Engineers comments in respect to surface water drainage and land drainage below. Please note these comments also relate to relevant conditions on F/6/20/DOC, but since they are all related, the comments have been amalgamated together.

APPLICATION NO: F/9/20/DOC

Site Address: Wicks Farm Ford Lane Ford BN18 0DF

Description of Works: Approval of details reserved by condition imposed under ref F/30/18/PL relating to Condition No 3 - surface water drainage.

PROPOSED DRAINAGE LAYOUT PART 3

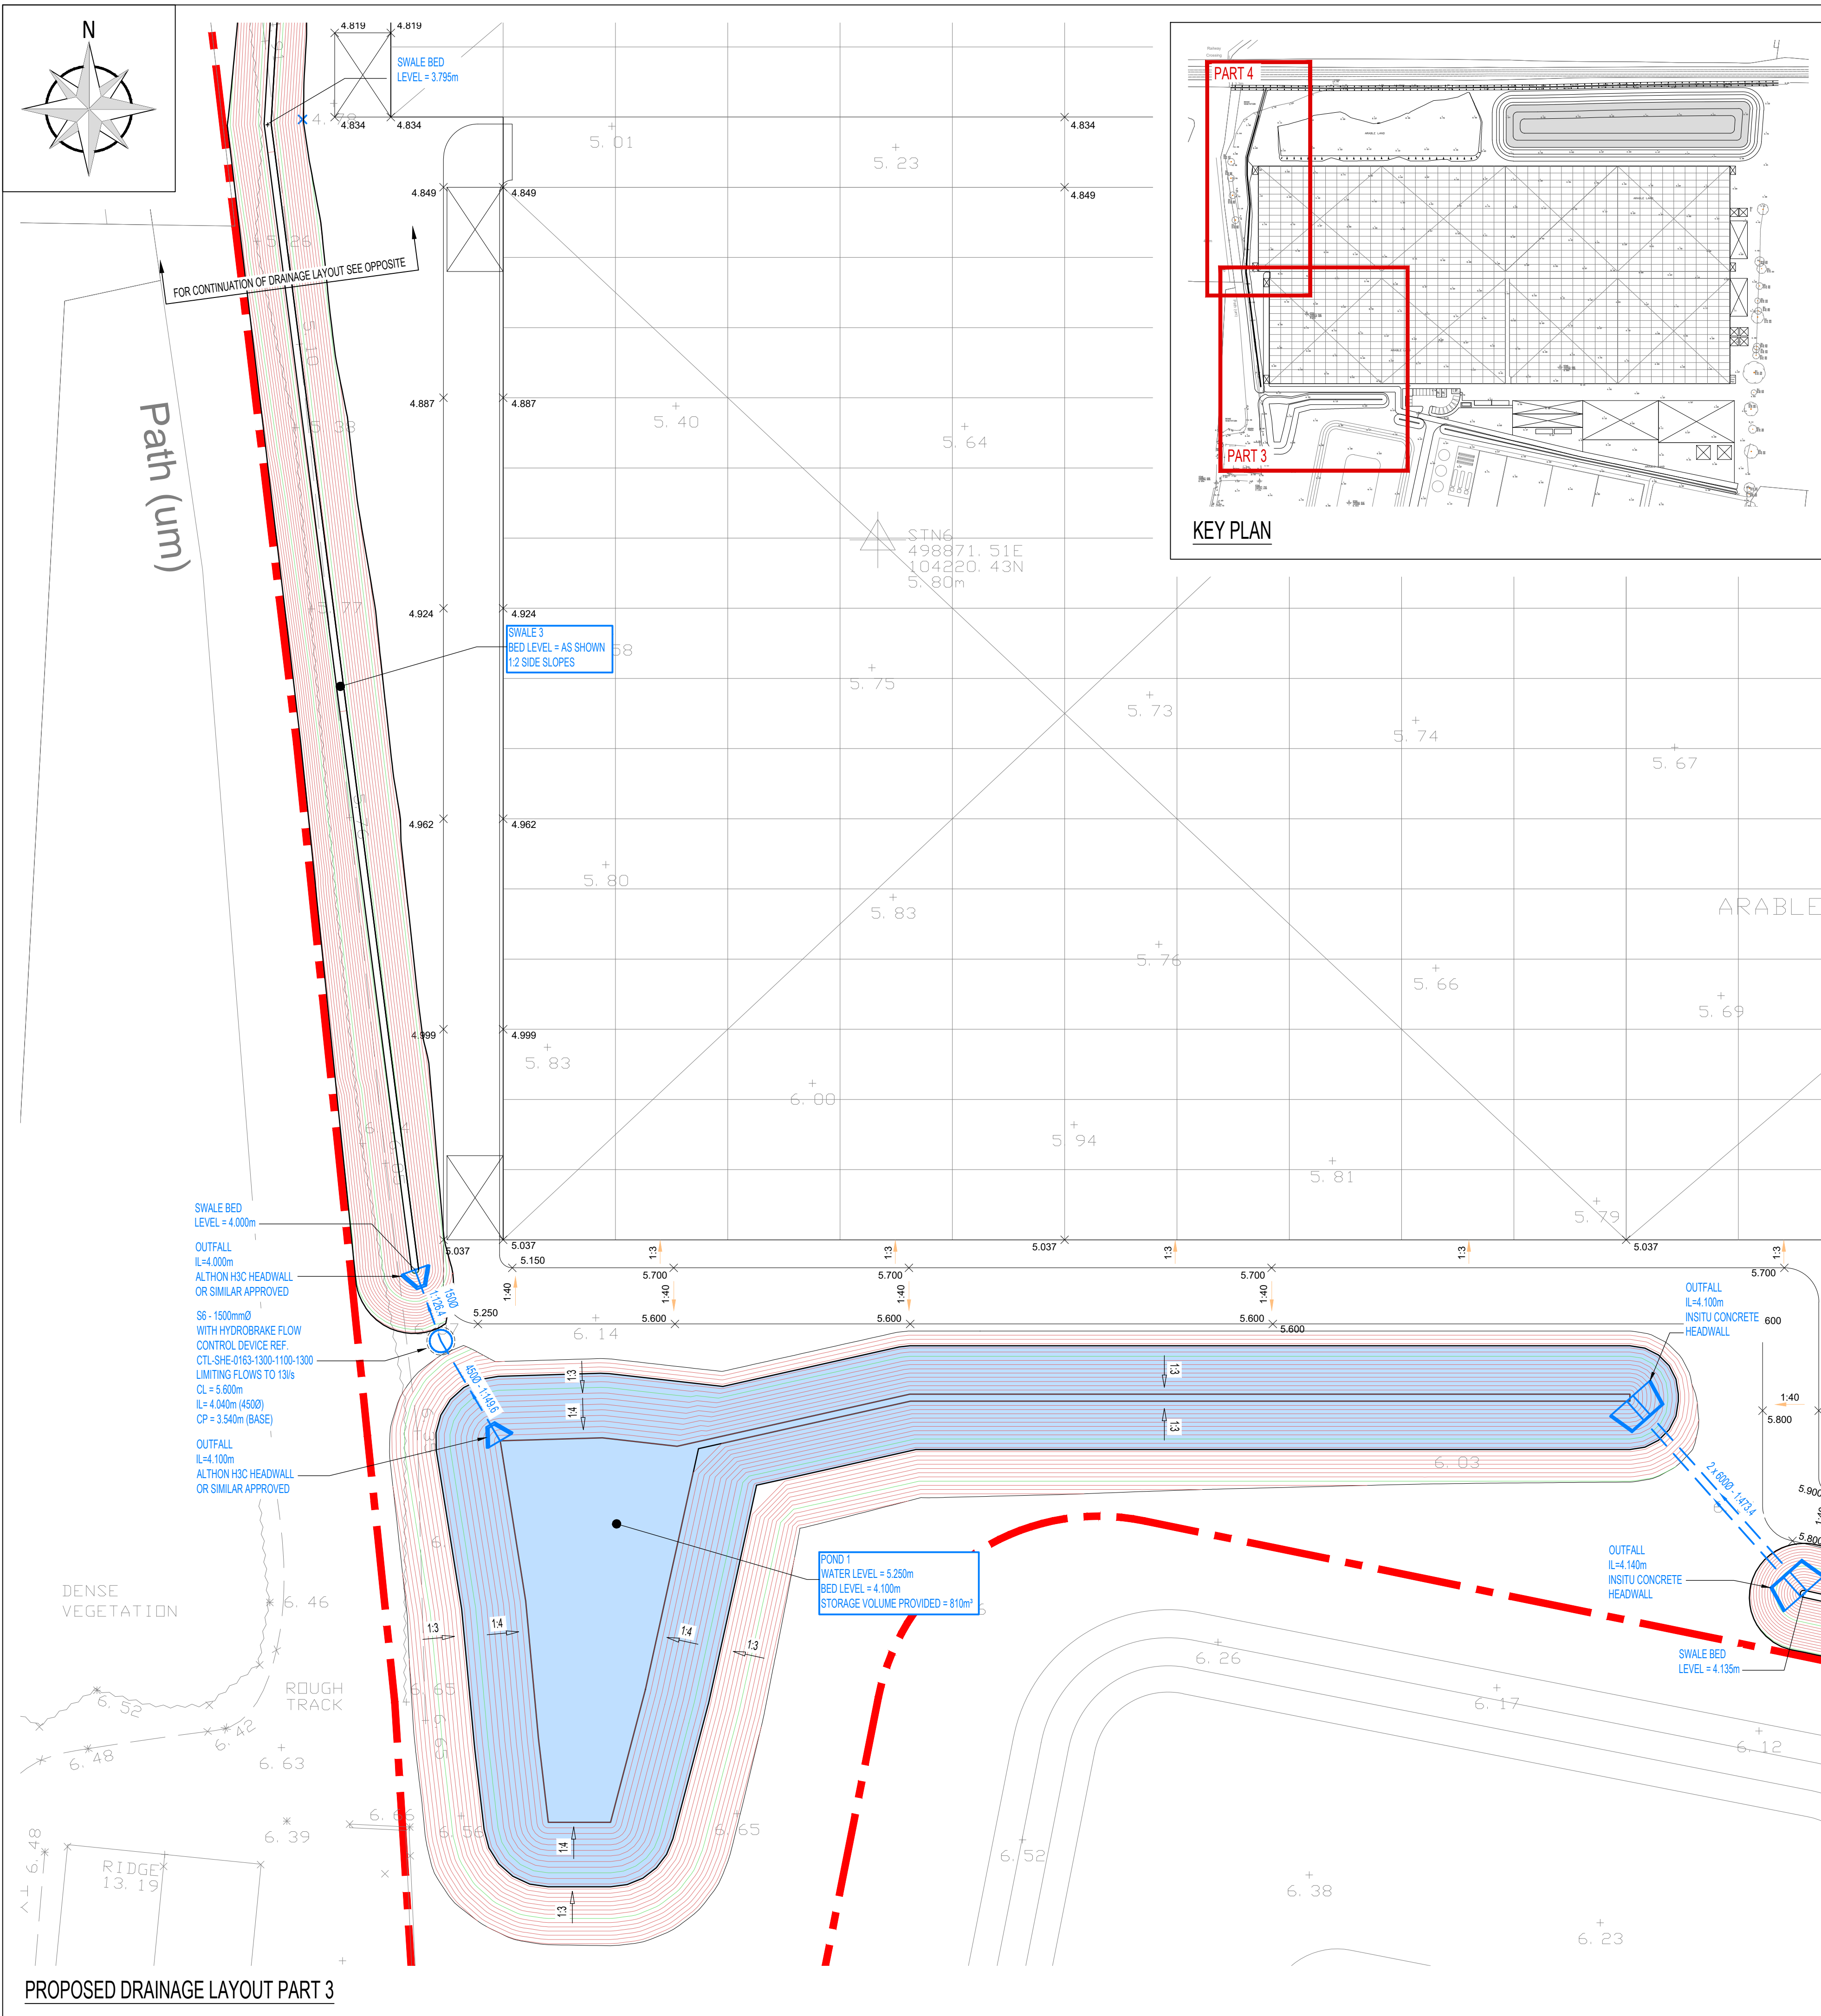
2. Is there a ditch on the eastern boundary? If so, include details on the plans.
3. Please show the ditch on the western boundary on the plans. As per discussions with John Hall following a visit to site, it was noted that some sections of the ditch have been re-dug, whilst the section before discharge to the Network Rail ditch needs maintenance and un-filling where the dead tree is located. Please add suitable notes regarding the intended proposals.

4. The existing northern boundary ditch is located within Network Rail land. As discussed, the intention is to now provide a new ditch parallel to that one and discharge to the western boundary ditch. Please also the drawings as necessary and provide a typical cross section and a longitudinal section.

5. Provide fully detailed construction drawing for the reservoir, including base levels and top of bank levels.
6. Specify pipe invert level where discharging to northern ditch, ensuring as much freeboard as possible between ditch bed and pipe invert.

TYPICAL SECTION SHOWING SWALE 1 PROFILE

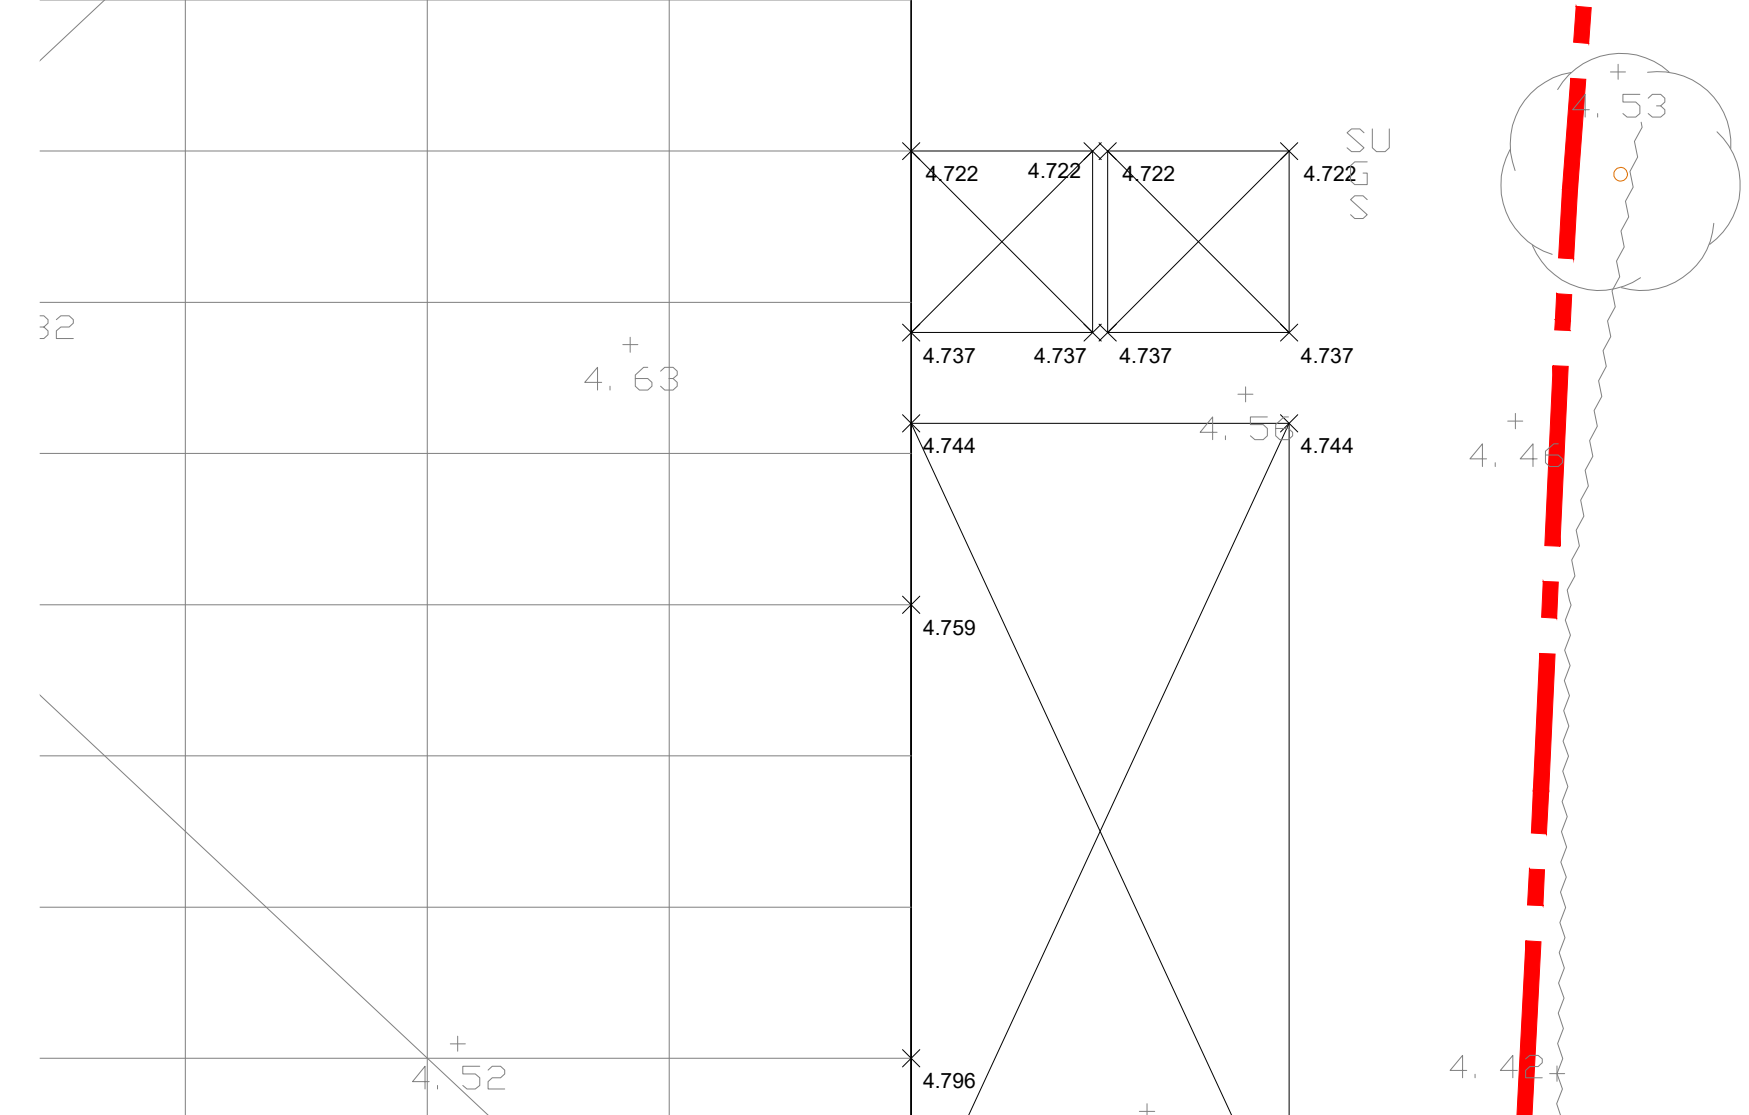
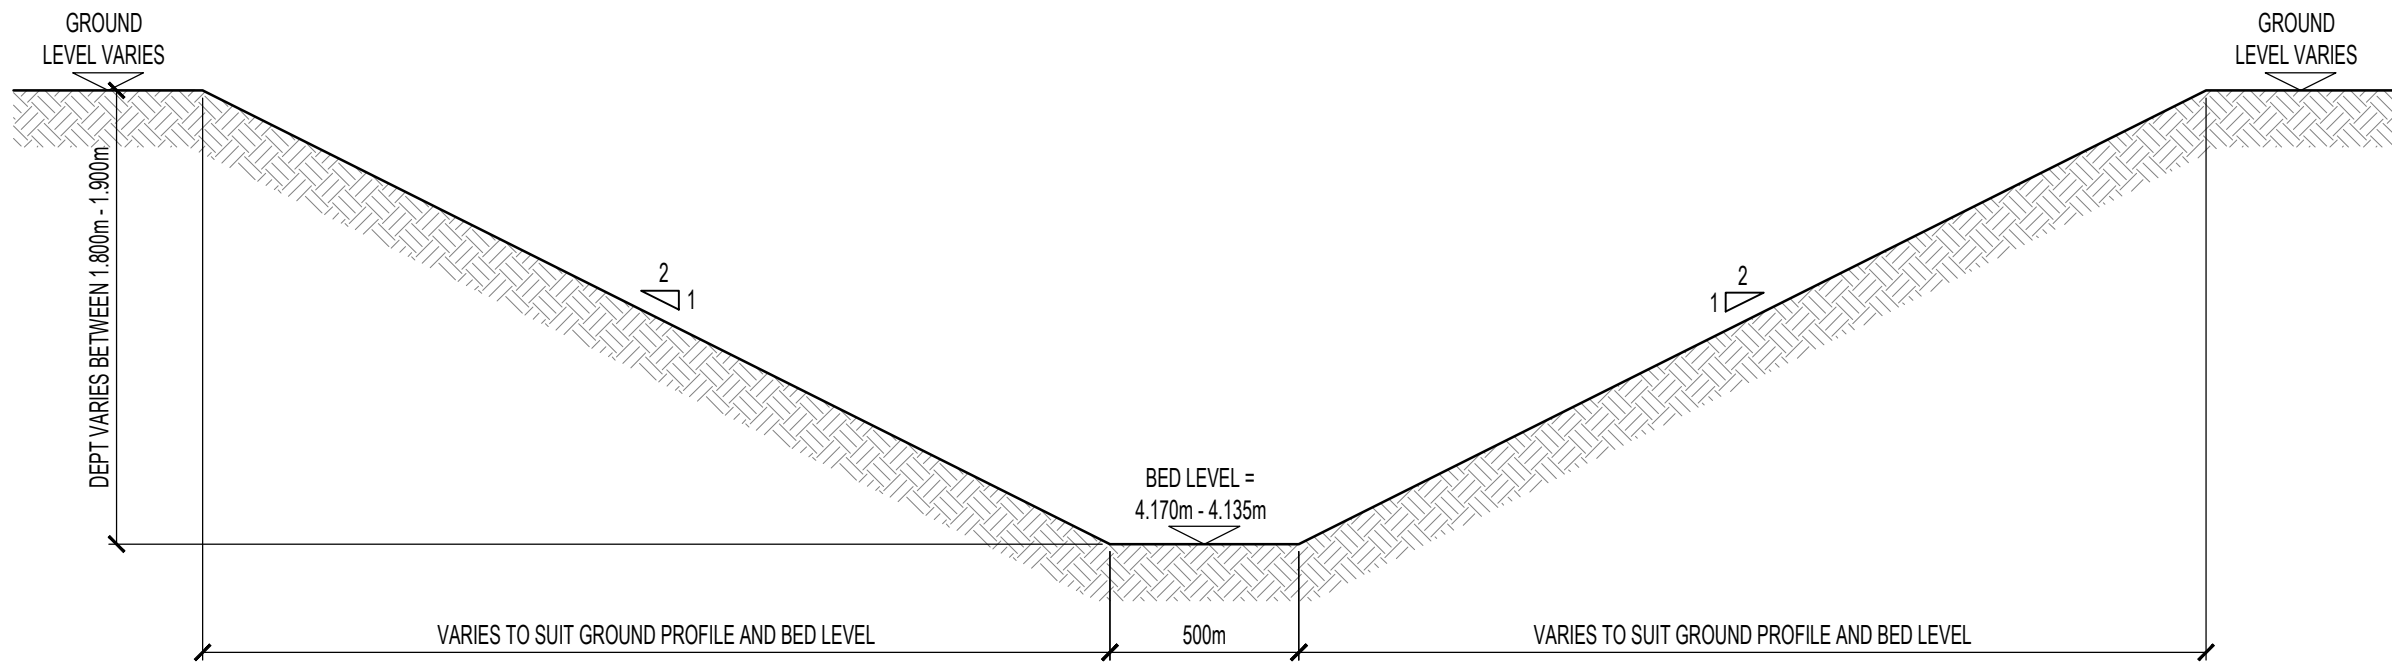
21. Outlets to swale 1 – provide min. 100mm freeboard between swale bed and pipe inverts.
22. Provide positive fall on pond 1 (swale) bed.
23. All pipes to connect soffit to soffit unless otherwise specified – add note.

TYPICAL SECTION SHOWING SWALE 2 PROFILE

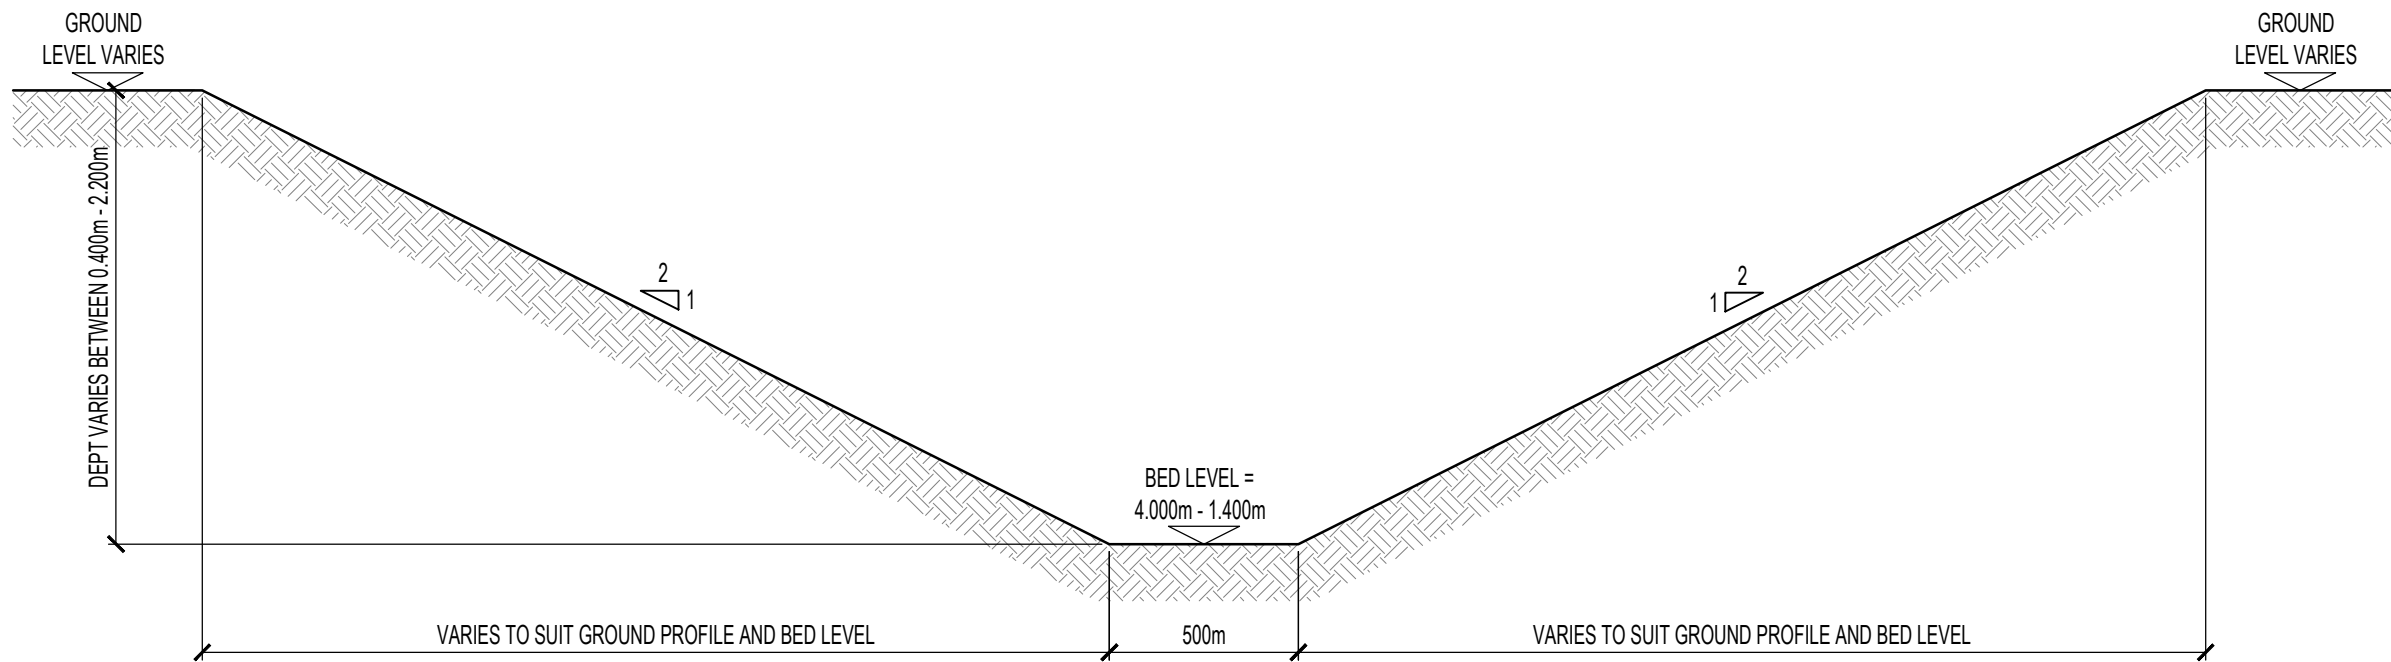
16. Incoming 225mm pipe to swale 2 – provide min. 100mm freeboard between swale bed and pipe invert.
17. Pipe concrete bed and surround detail – specify the specific concrete mix on the detail itself.

TYPICAL SECTION SHOWING POND 1 PROFILE

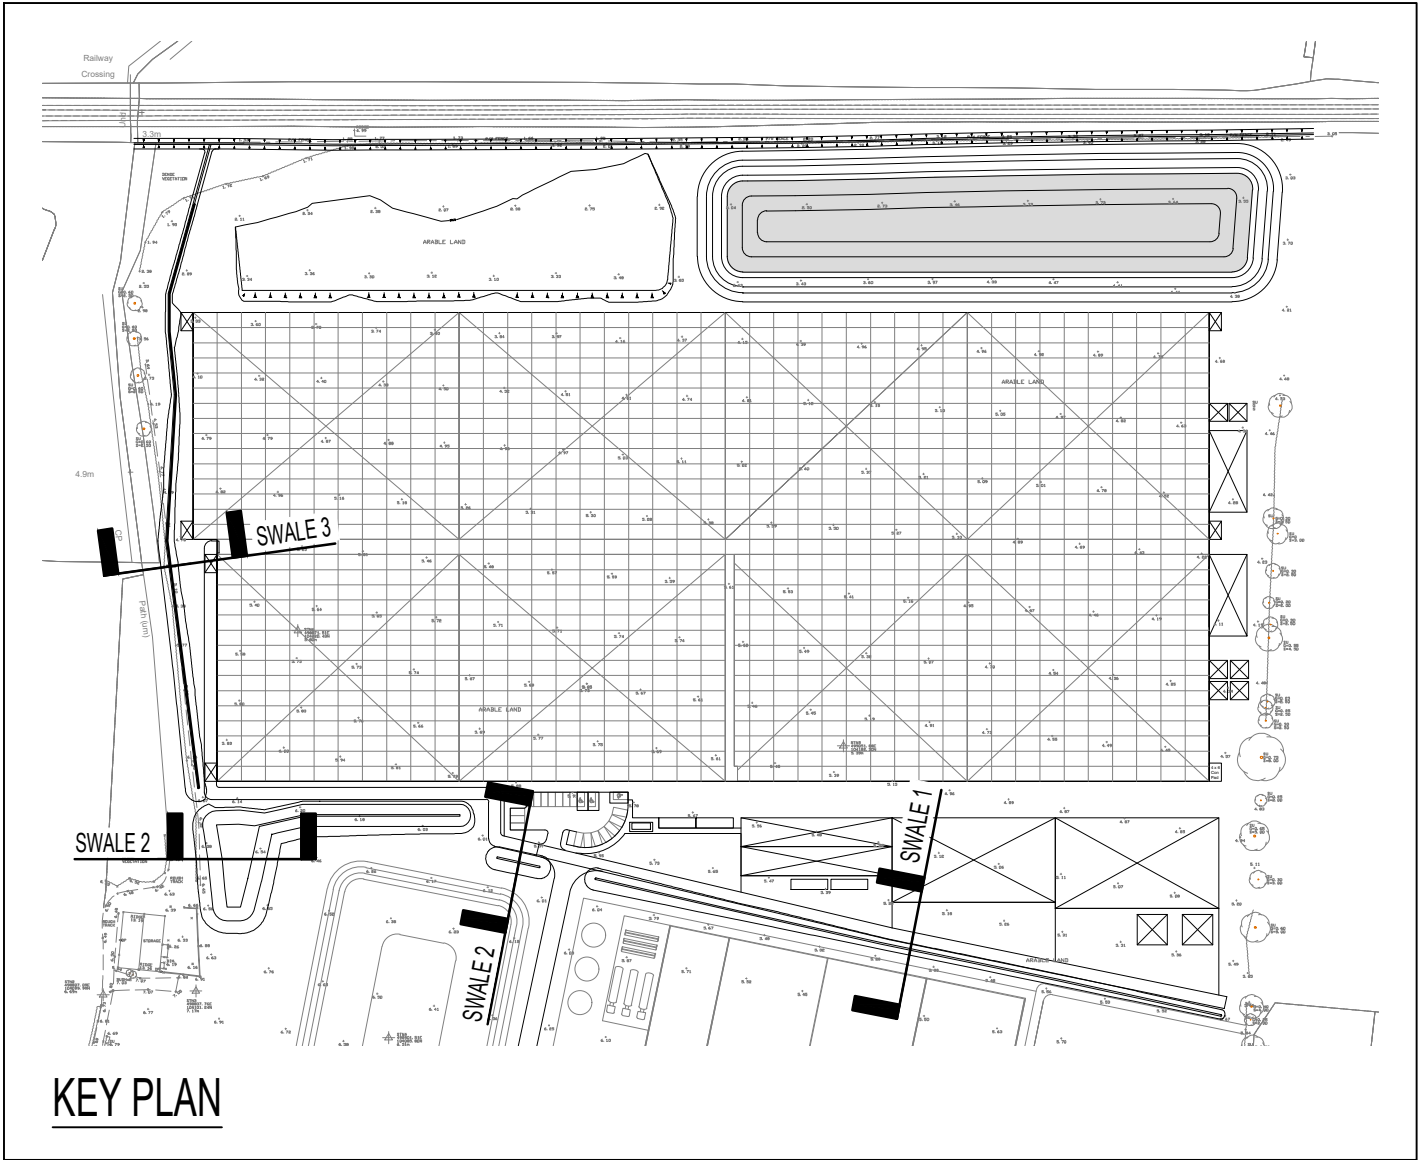
26. Pond 1 and associated swales – show top of bank levels on all sides.
27. Provide causeway flow calculations for reservoir system. The CEP calculations provided were only preliminary and do not reflect the actual design.
